**Subject:** RE: EA comments on flood compensation for undercrofts - Planning Application 16/00472/OUT - Grundon Waste

**Subject:** EA comments on flood compensation for undercrofts - Planning Application 16/00472/OUT - Grundon Waste

90.15m AOD CONTOUR PROPOSED 17009m²

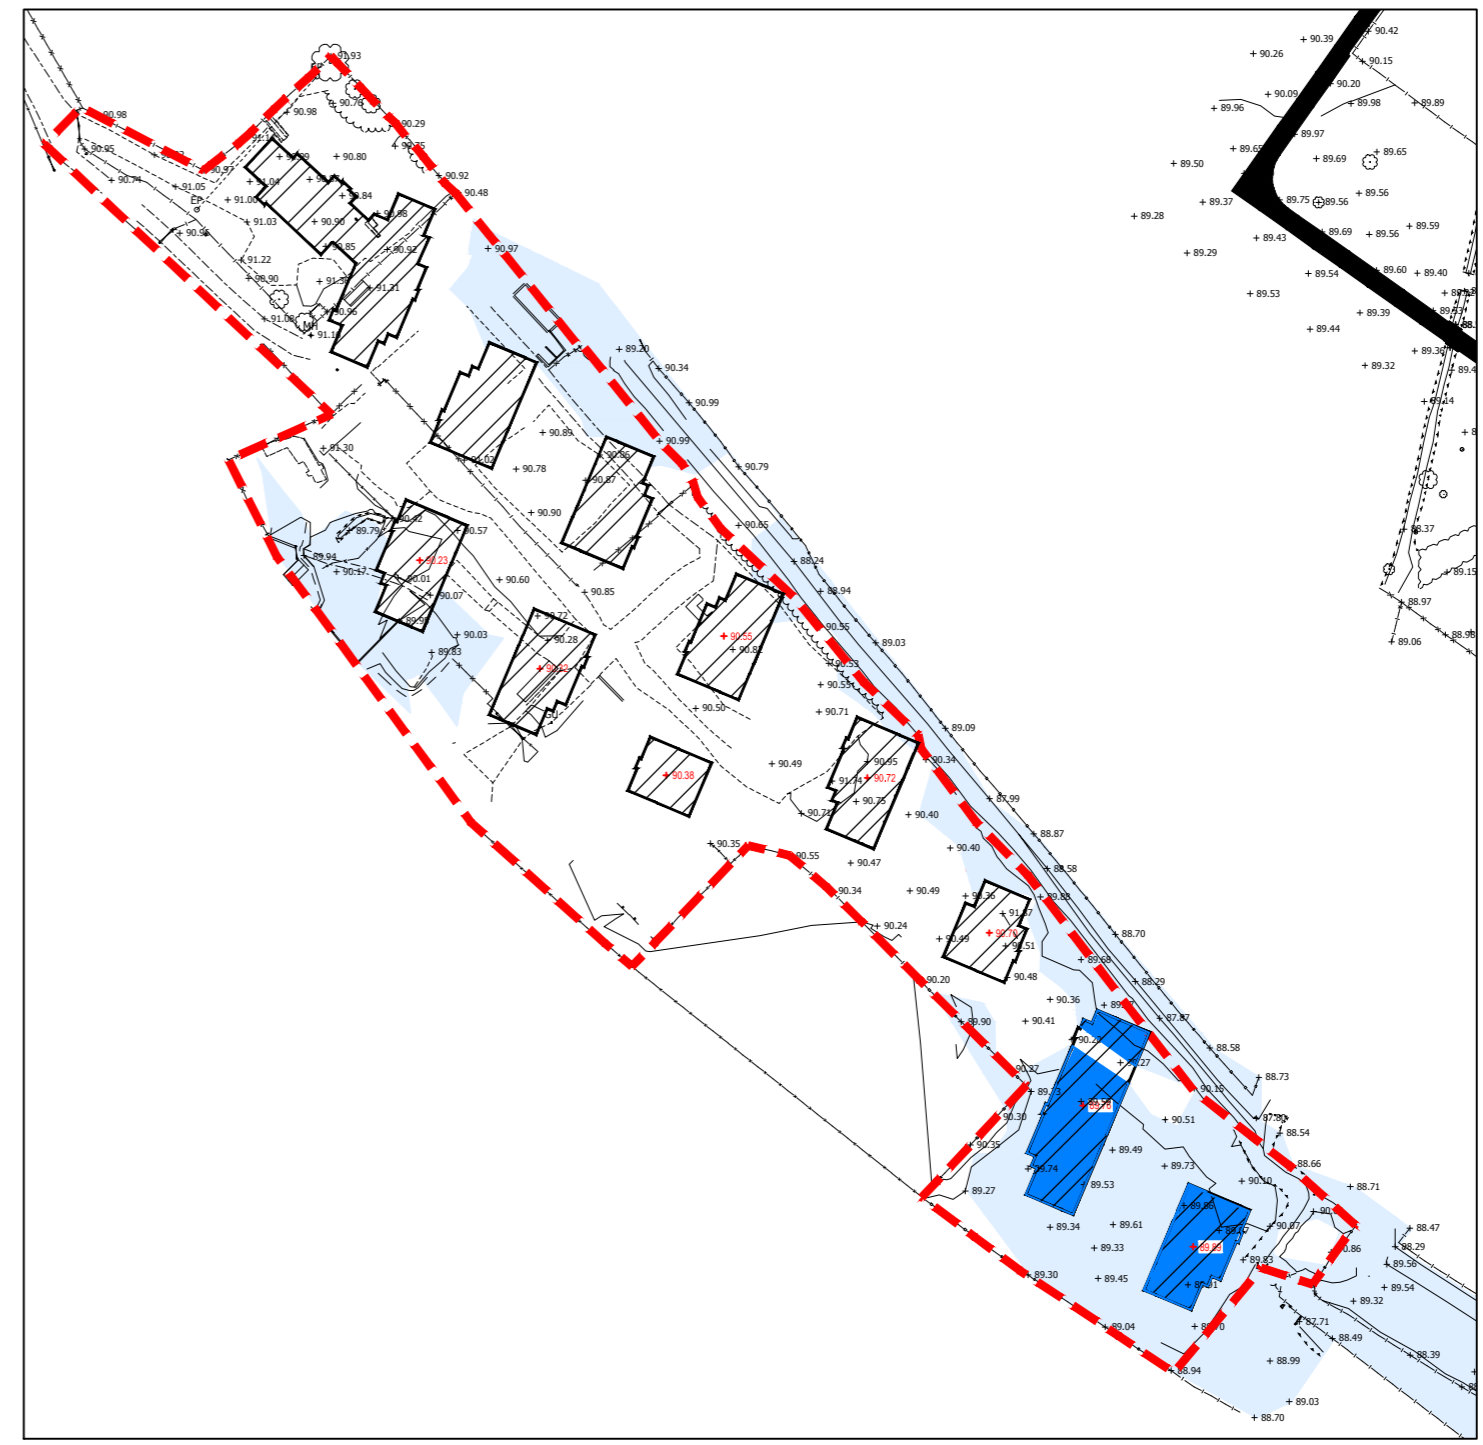
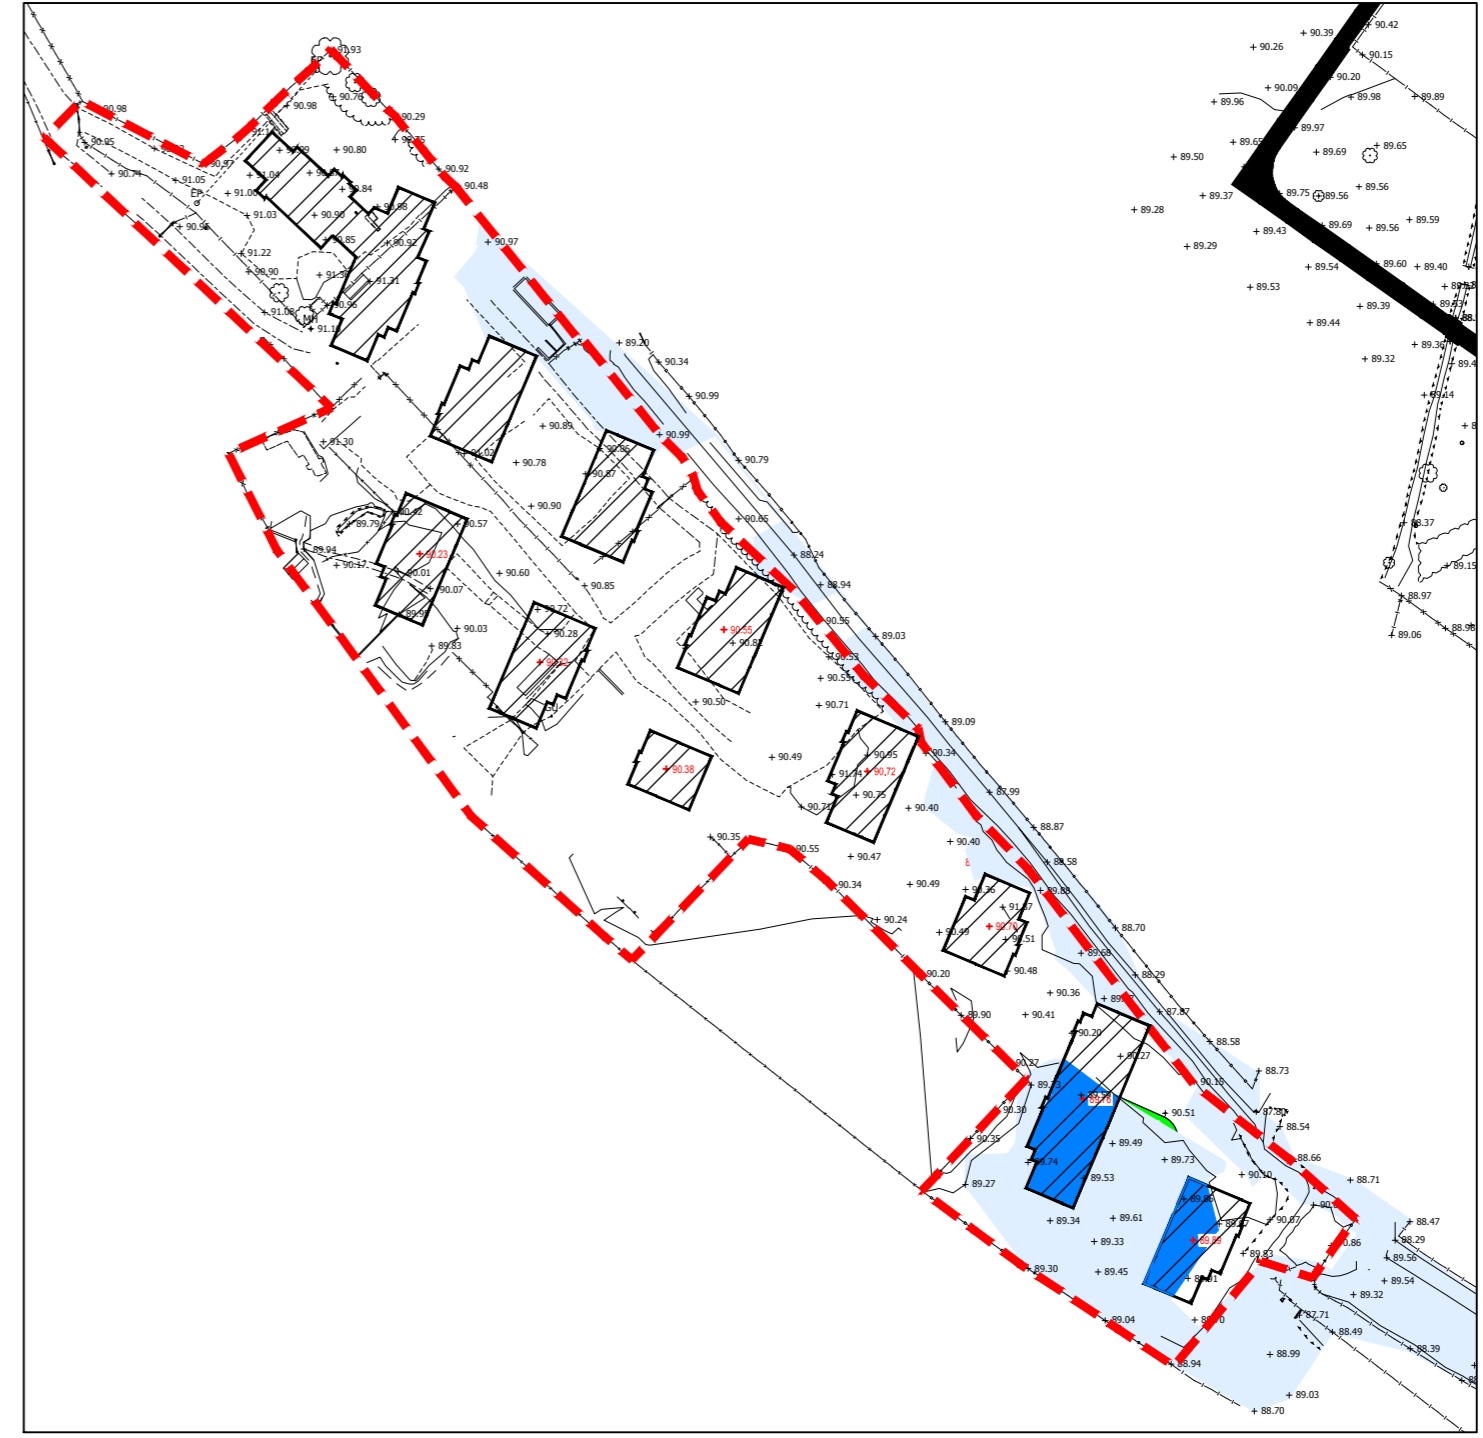
The proposed flood compensation drawing for Grundon Waste Management Depot Banbury, prepared by Peter Brett Associates, reference 33390/4001/ 005, shows 6 cut through diagrams. These range from 89.75m<sup>2</sup> to 90.15m<sup>2</sup>, in cut throughs of 200mm, with 600mm between all 3.

We have looked at the 3 cut throughs and the differences between the existing and proposed volumes. We have calculated the proposed storage multiplied by 0.2 (representing the 200mm flood depth) and did the same for the existing storage. We then worked out the existing storage minus the proposed storage.

For example in the 89.75m cut through  $0.2 \times 8337 = 1667.4$  and  $0.2 \times 8378 = 1675.6$  then  $1675.6 - 1667.4 = 8.2$ . As a result we end up with a gain of 8.2 and 127 which equals 135.2 but a loss of 174.4 giving an overall loss of 39.2.

It is unclear if the volumes provided account for the whole building or for the footprint of the building lost. Please feel free to clarify via additional documentation if we have misunderstood this view.

I have looked at your flood storage calculations and think there has been some misunderstanding on how we are increasing the overall storage volume on site in the each of the volume for volume bands, whilst the overall area of floodplain is being reduced in the 89.95 m band.

Your volume calculations are basic as you are assuming an even depth of flooding (0.2 m) at each band. However in reality the ground levels at each band are not set to a flat level of 89.75, 89.95 and 90.15 m but, as natural ground levels, they will have varying depths of flooding at each level. Your volume estimates assume a prismatic volume which would over estimate the total volume at each band in the baseline and post development schemes.

Additionally I think there was a miscalculation in your estimate volumes in your email below. Where you are suggesting a 127 m<sup>3</sup> gain in the 89.95 to 90.15 m band, it should be, by your calculations (17009-13834) \*0.2 = 635 m<sup>3</sup> gain (you may have accidentally multiplied the 635 by another 0.2 to get the 127 figure?). However as I have explained your volume calculations overestimate the actual volumes on site.

Our drawing 33390/4001/004 shows the volume calculations based on the 3d model of the groundworks we created to assess the floodplain compensation, showing the net gains in volume, within the building footprint and outside the building footprint, at each band and the overall gain of 576.4 m<sup>3</sup>.
